NORWICH TO TILBURY

EN020027

Comments on Submissions received at Deadline 1

12 March 2026

Drawing Number: 10059280-ARC-EGN-ZZ-DR-ZZ-00882 Revision: A

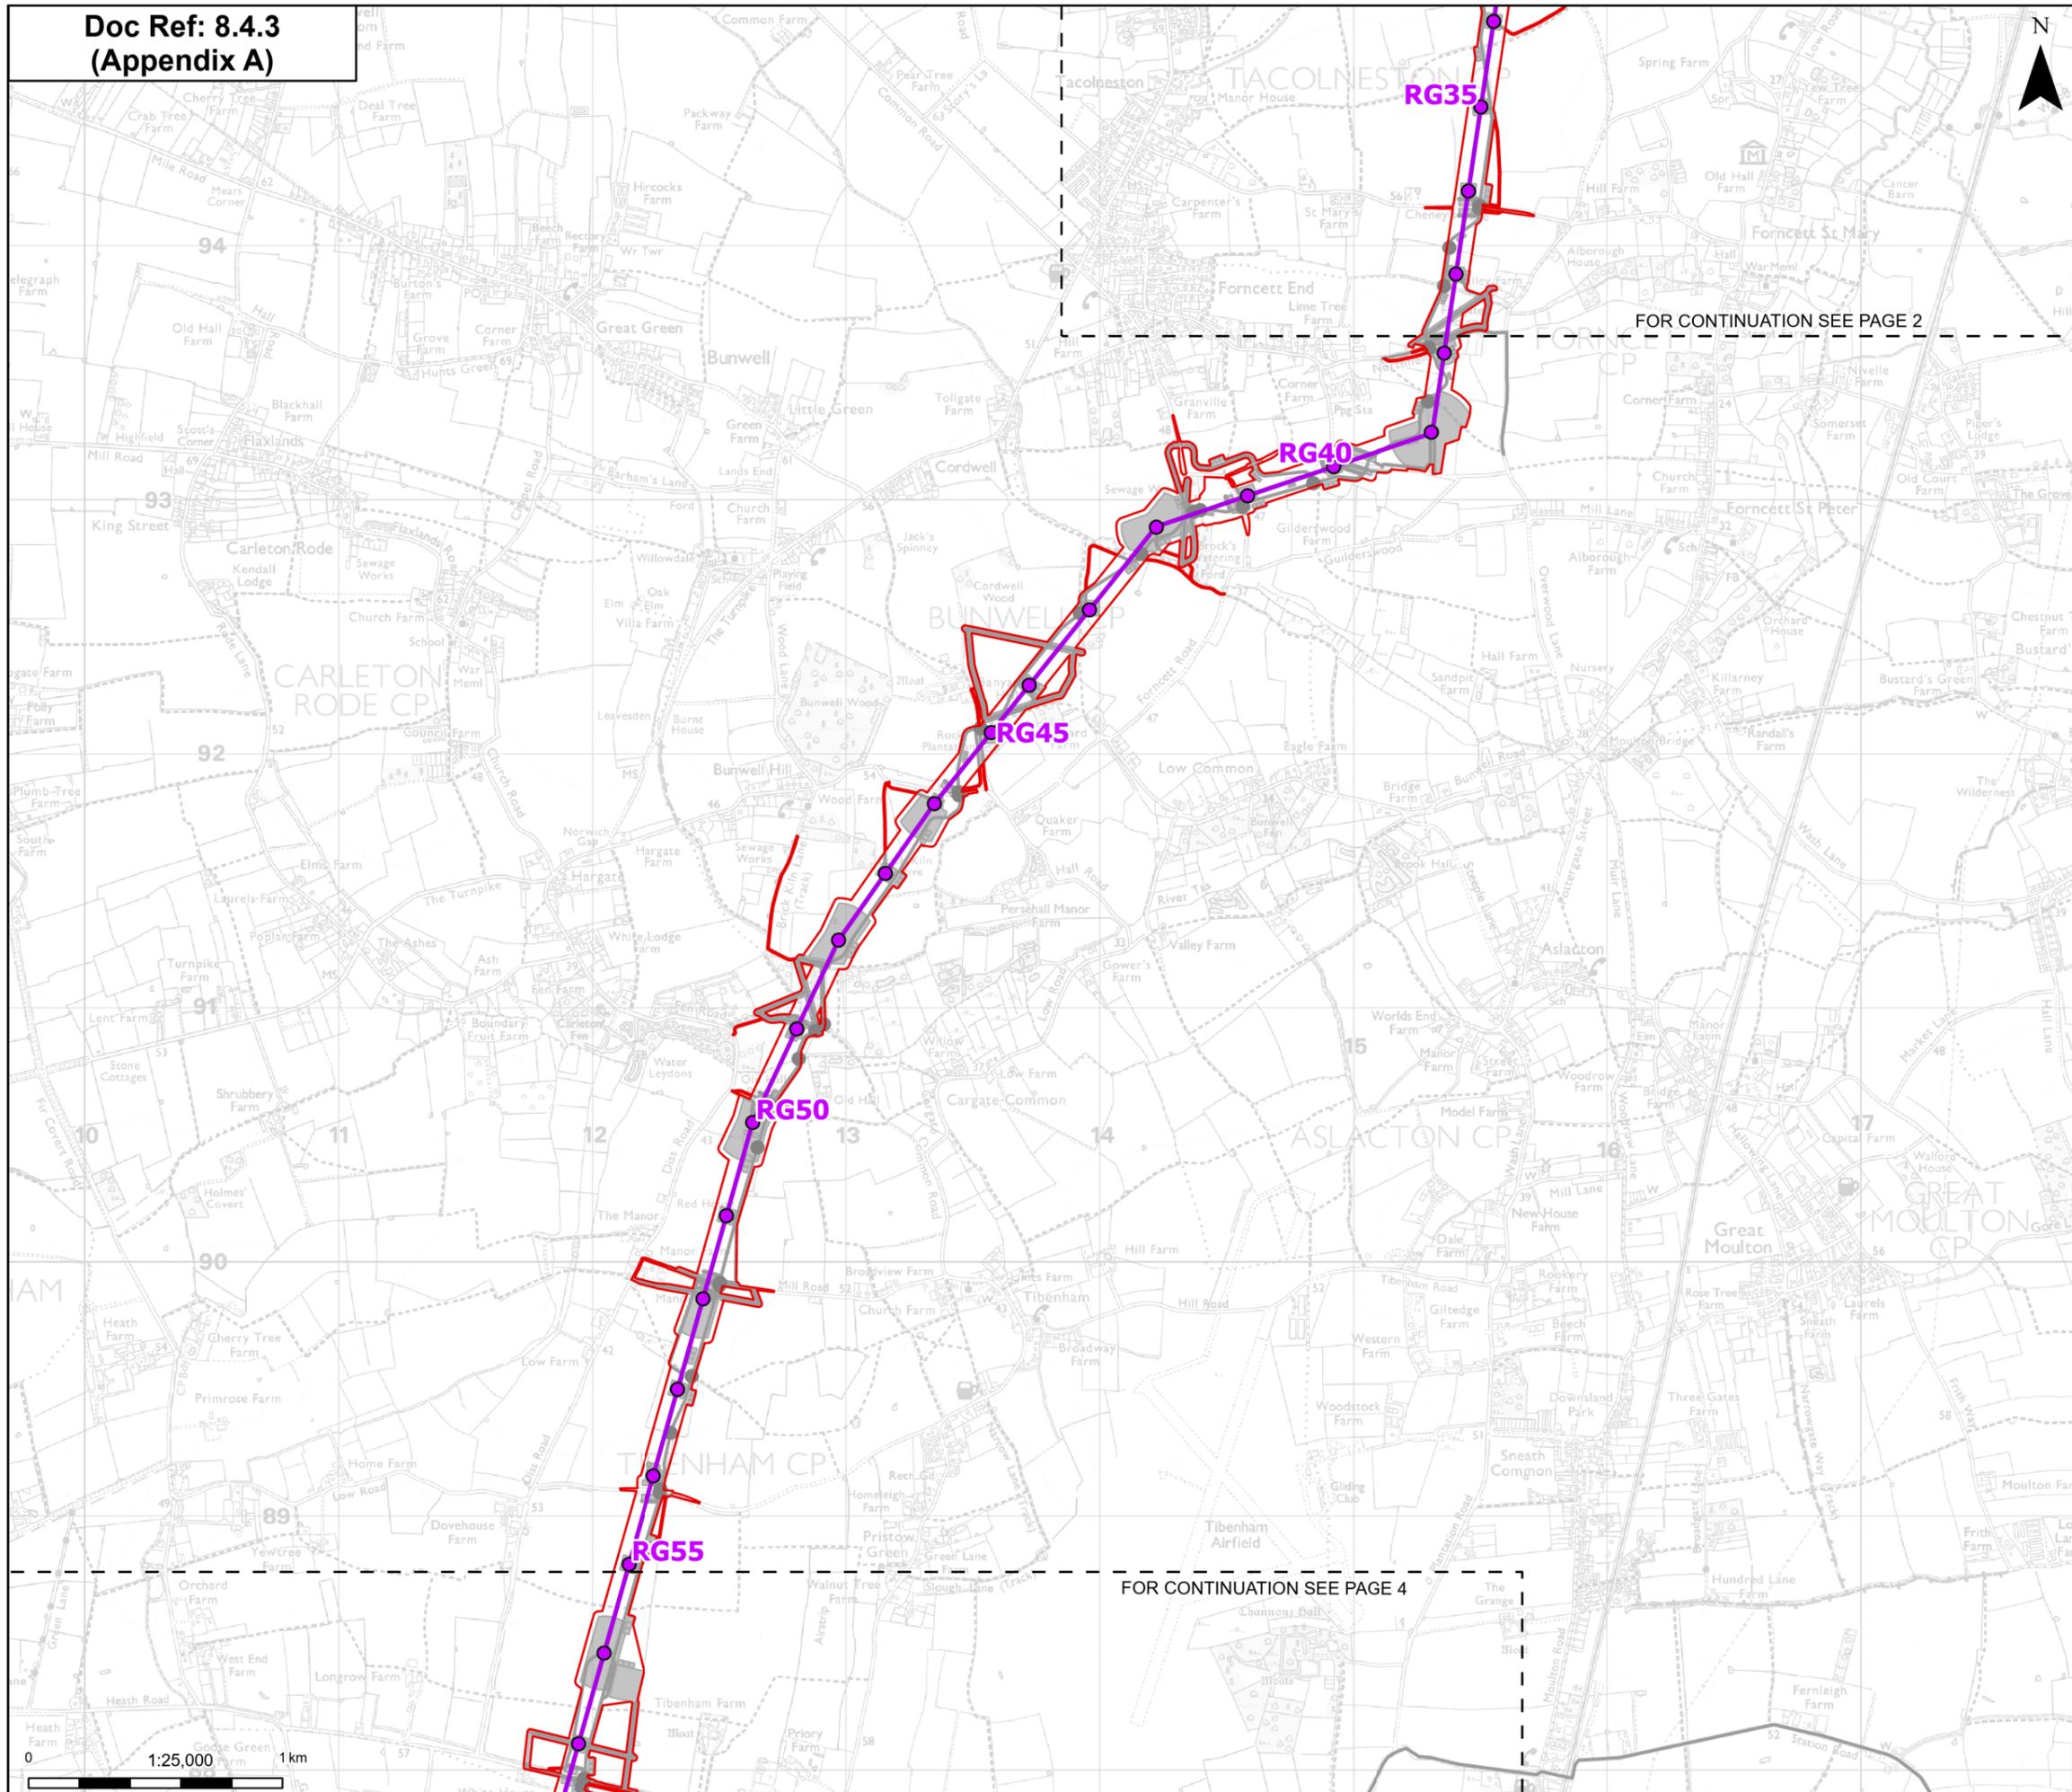
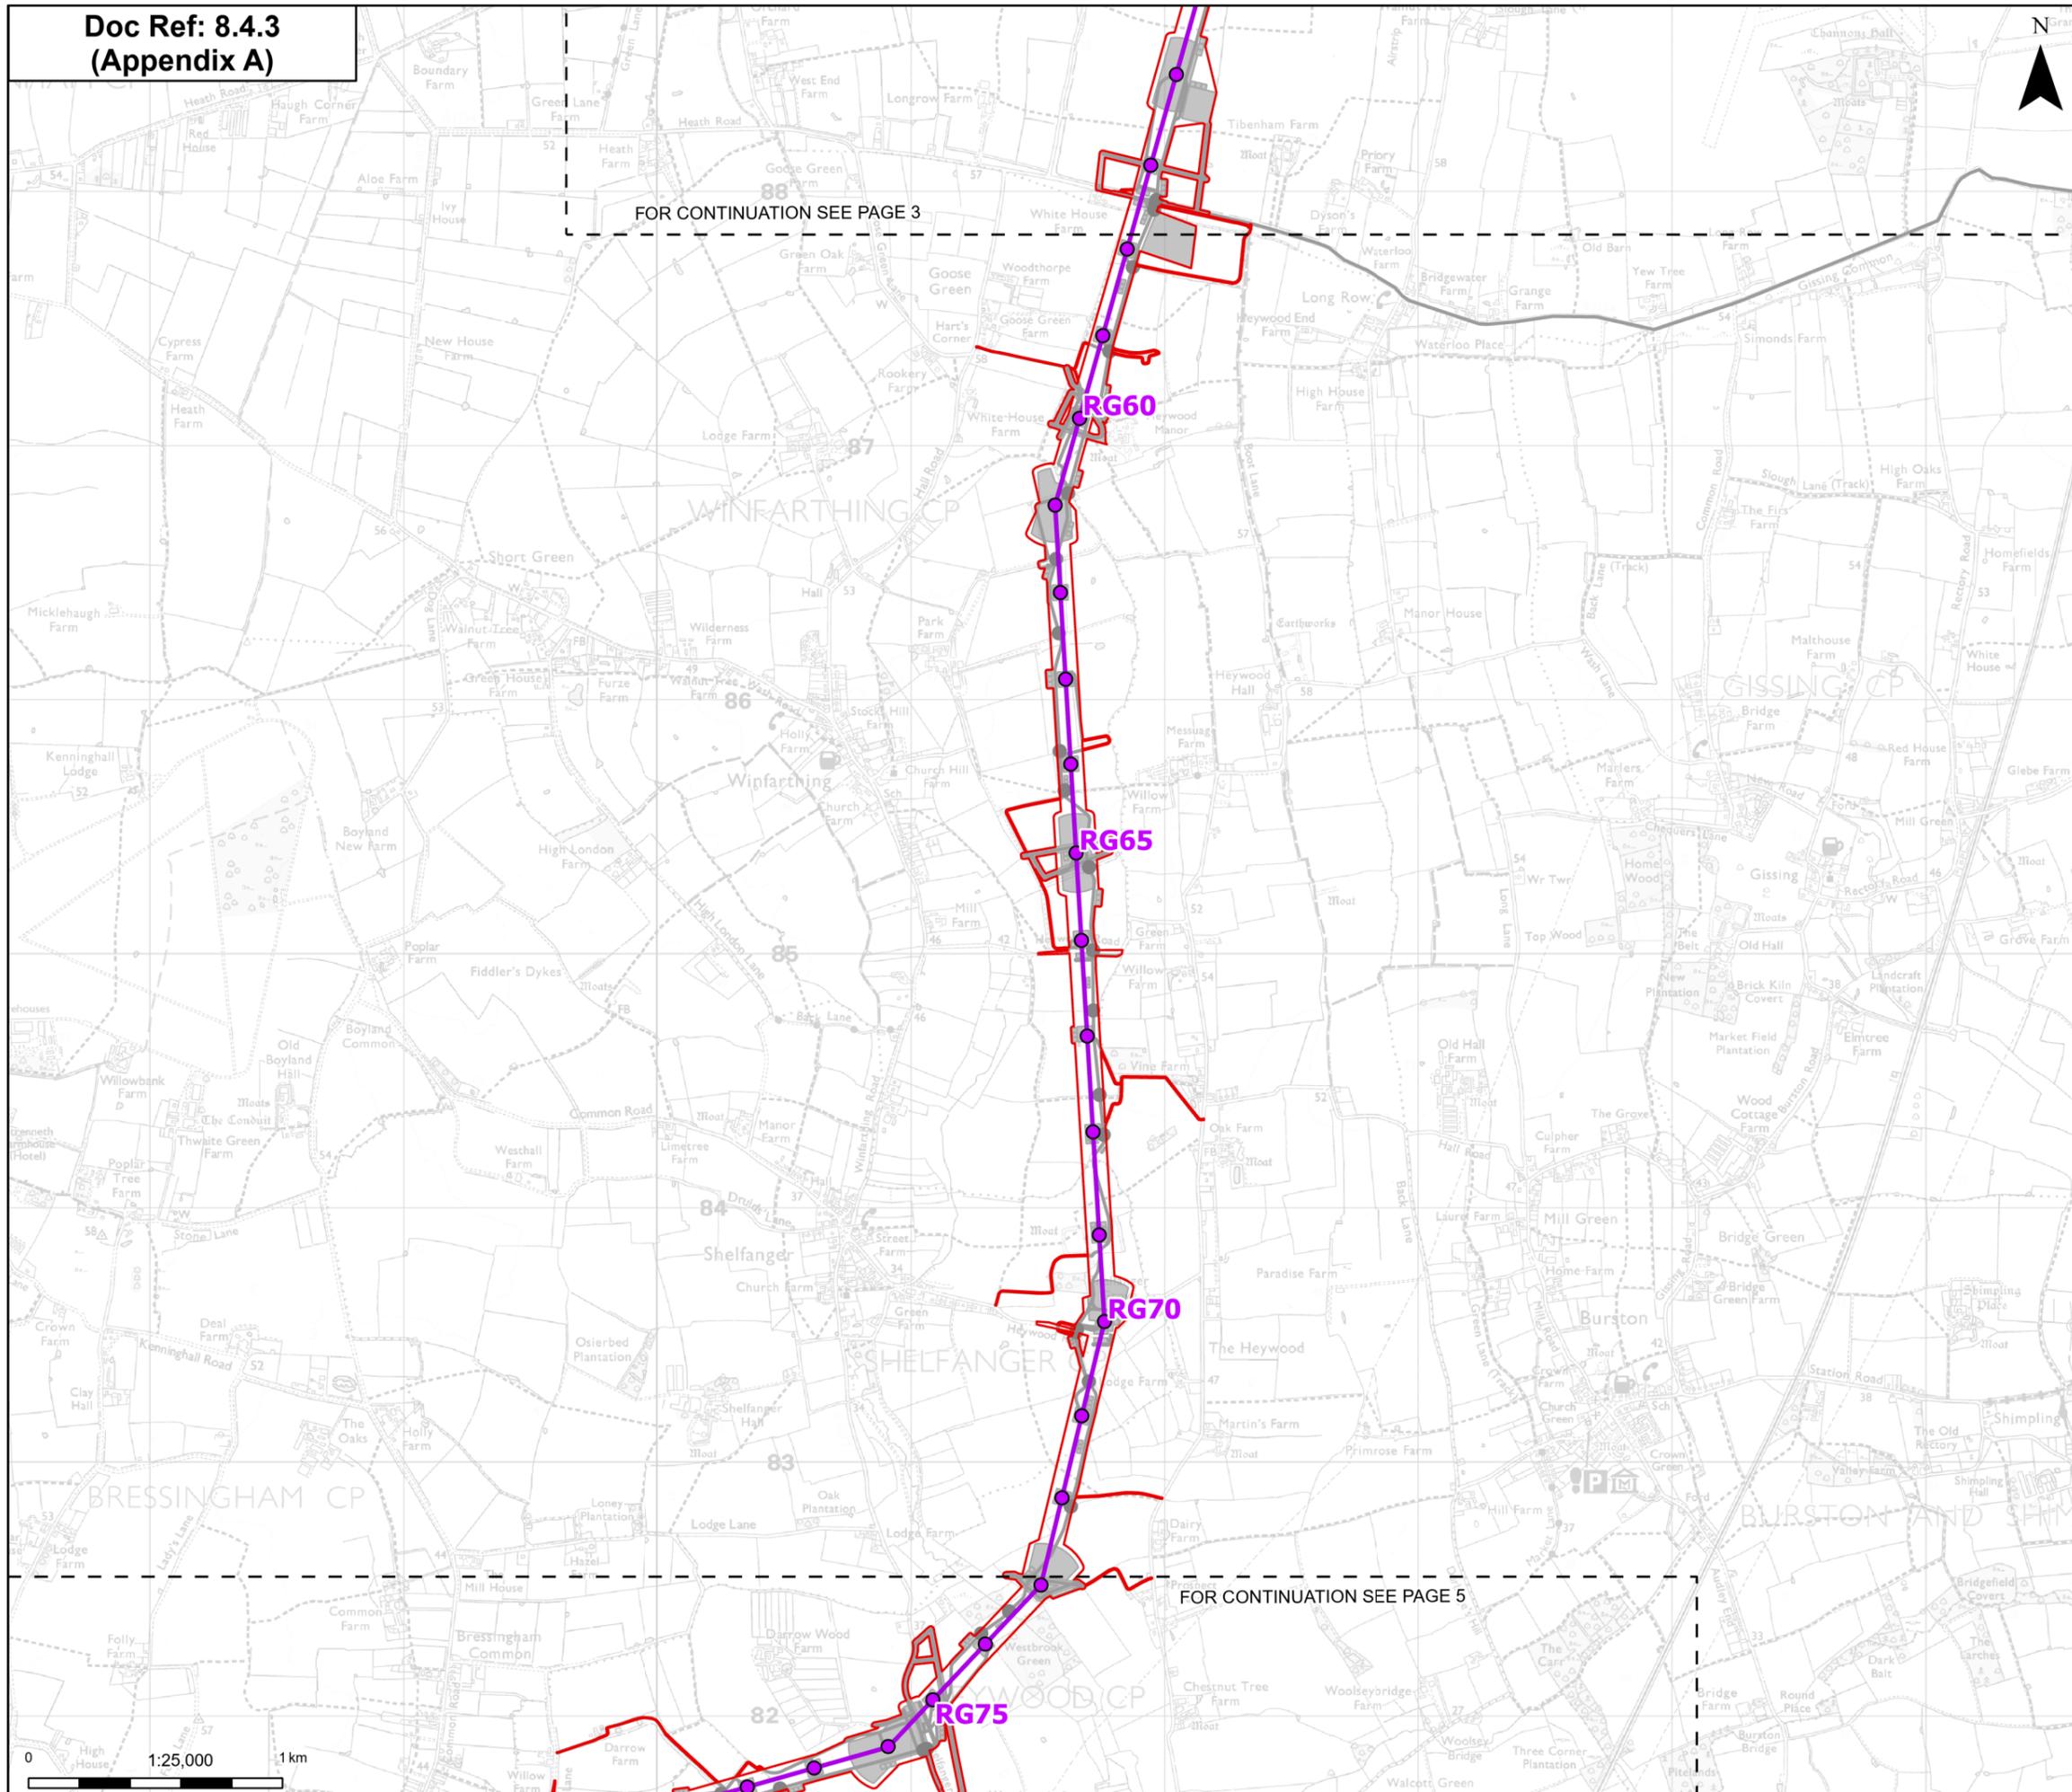
1l	Lead officer	Appendix A	The drafts order limits for the EcoPower Suffolk solar NSIP are not shown
